RE: **Sierra Platinum Apartments - 4100 Silver Ave, NE**
Grading & Drainage Plan for Building Permit
Engineer's Stamp Date 3-20-2014 (H17/D108)

Based upon the information provided in your submittal received 3-20-14, the above referenced plan cannot be approved for Building Permit until the following comments are addressed:

GRADING PLAN

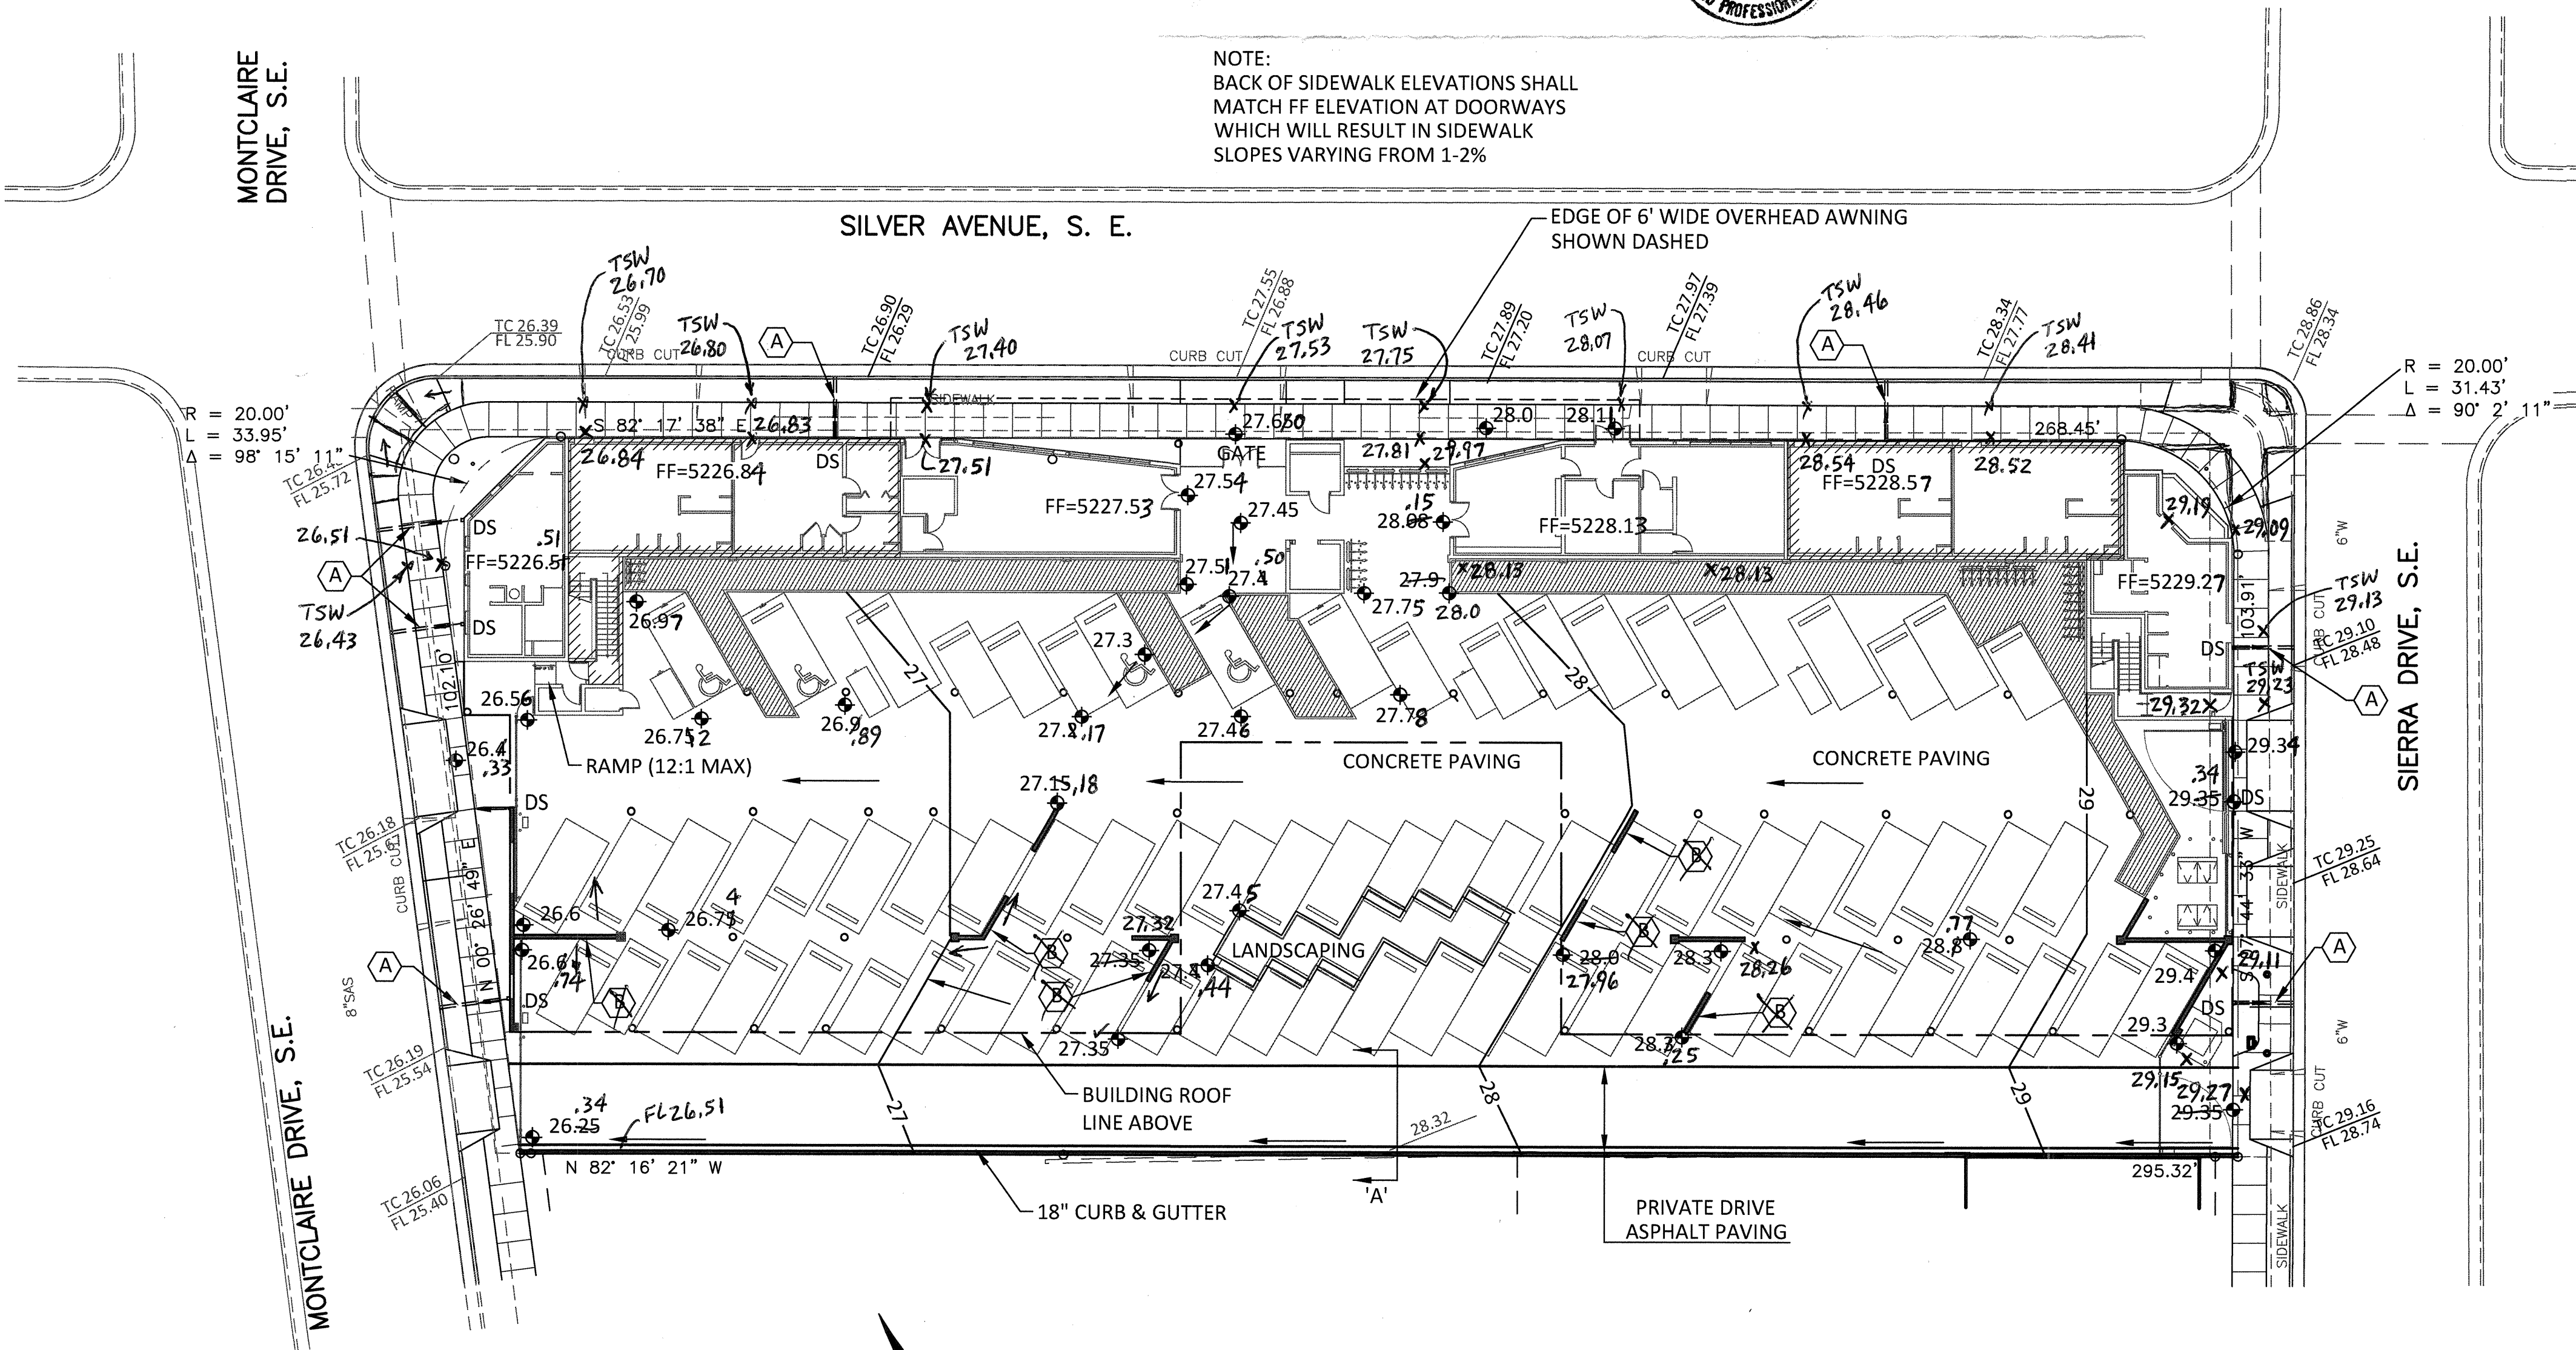
1. Show spot elevations at Top of drive pads along Sierra Drive to ensure FL is at a lower elevation.
2. Indicate the edge of awning on the North side of building, and note that it drips into the landscape strip.
3. Indicate that the Back of Sidewalk matches FF elevation and the sidewalk slope varies from the standard 2% slope.
4. Indicate the TC elev. on the North side of bldg. near the entrance.
